Planning Application Ref: LU/317/21/T

Location: Glenmore Court, Flat 3 St Winefrides Road, Littlehampton, BN17 5LY

Description of works: 3no. chestnut trees - re-pollard to previous points and remove deadwood

3 x chestnut

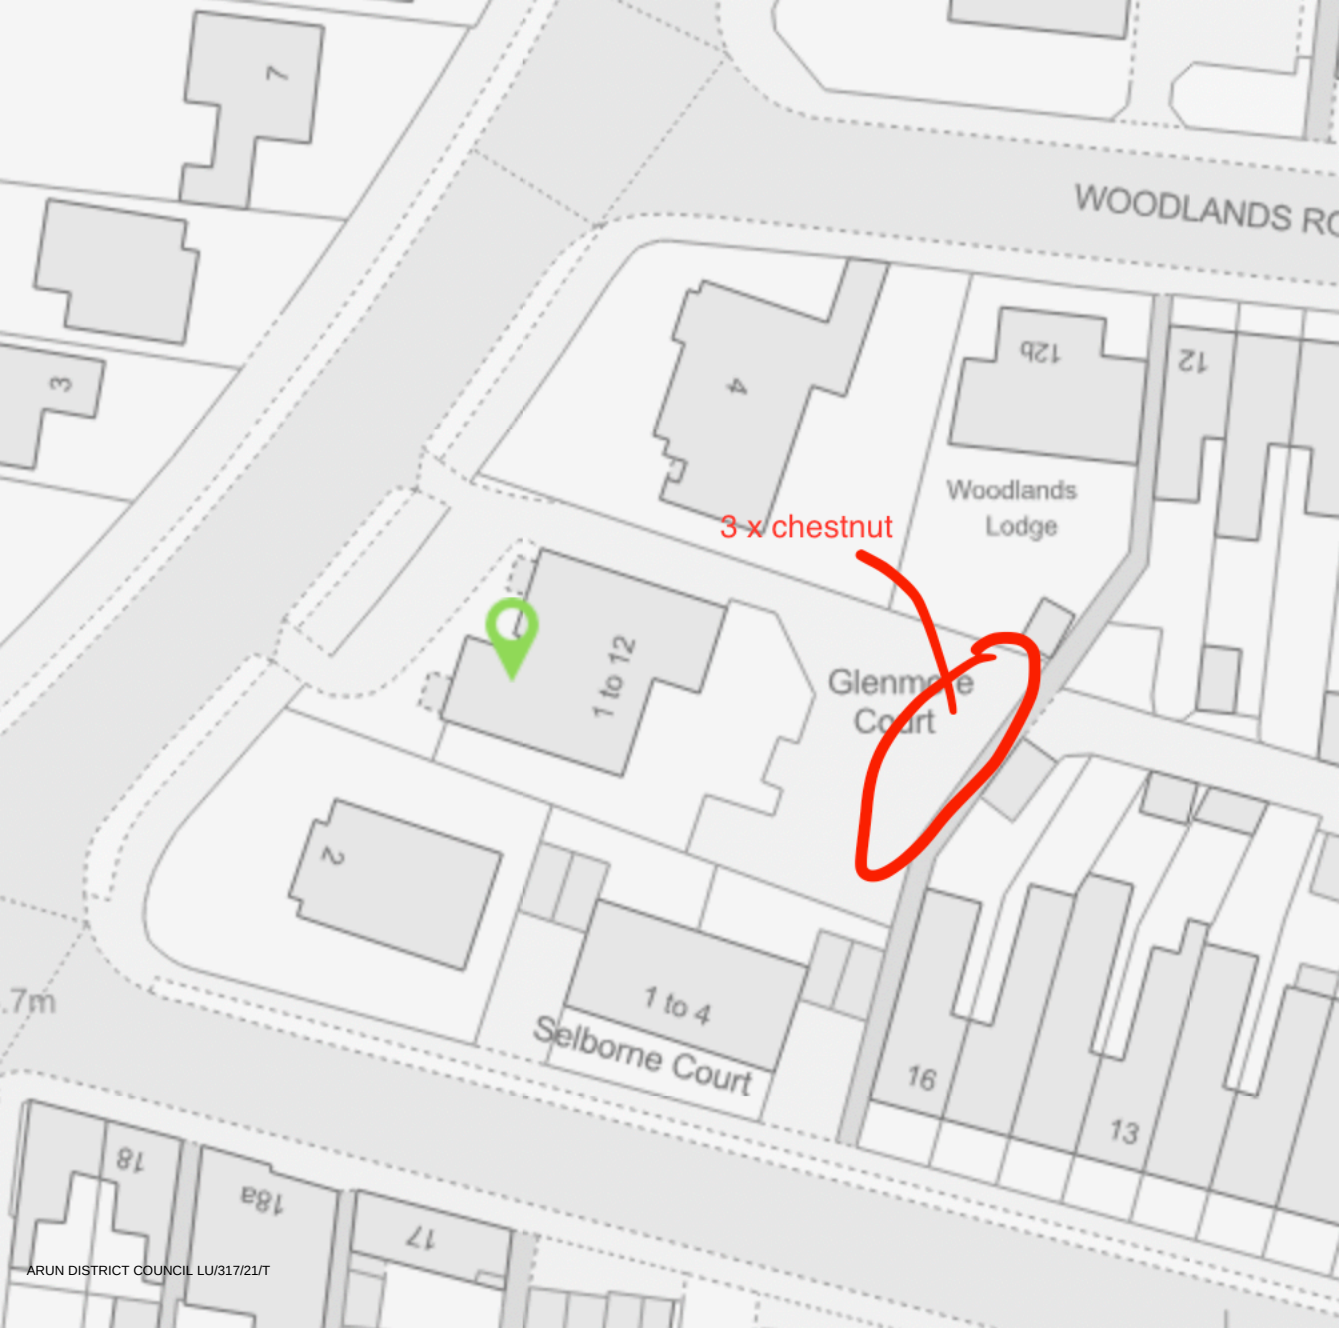
3x horse chestnut / *Aesculus hippocastanum* Height: 5-10m Radial spread: 0-5m Age class: Mature

- Outwardly and from a distance these trees appear to be in a fine physiological state, although a close inspection reveals numerous small cavities having formed at old pruning wounds and established knuckles (pollard points).

- When in leaf, these trees could provide some verdant appeal to an otherwise intensely developed area.
- At least two varieties of mushroom (unidentified) were observed growing in close association with the northernmost tree's roots. Whilst that fungi may be beneficial to tree growth; the likelihood is they are either consuming dead tissue or pathogenic.

- The work proposed is justified on arboricultural grounds. Repeat operations such as now being asked for by the applicant will be necessary throughout the remaining lifespan of these trees, to achieve a degree of structural integrity appropriate for their location.
- The proposal to reduce their overall height and spread with a view to restricting growth is justified and consistent with previous works approved by the Local Planning Authority.
- While a temporary loss of aesthetic value is inevitable, satisfactory canopy renewal and recovery should occur if the work is undertaken to a high standard and at an appropriate time of year.

- I recommend **CONSENT** for this application, subject to the following condition:

Part a) Where whole branches are to be removed and final cuts made close to the trunk or branch union they are to be made as shown in Figure 2 of BS3998:2010

Part b) Where branches are to be shortened back the final cuts are to be made at the correct angle shown in BS3998:2010 and adjacent to a live bud or lateral.

Part c) The removal of crown material which has developed since the last pollarding operation must be done sympathetically and with respect to established 'knuckles' so as not to extend beyond the point of origin.
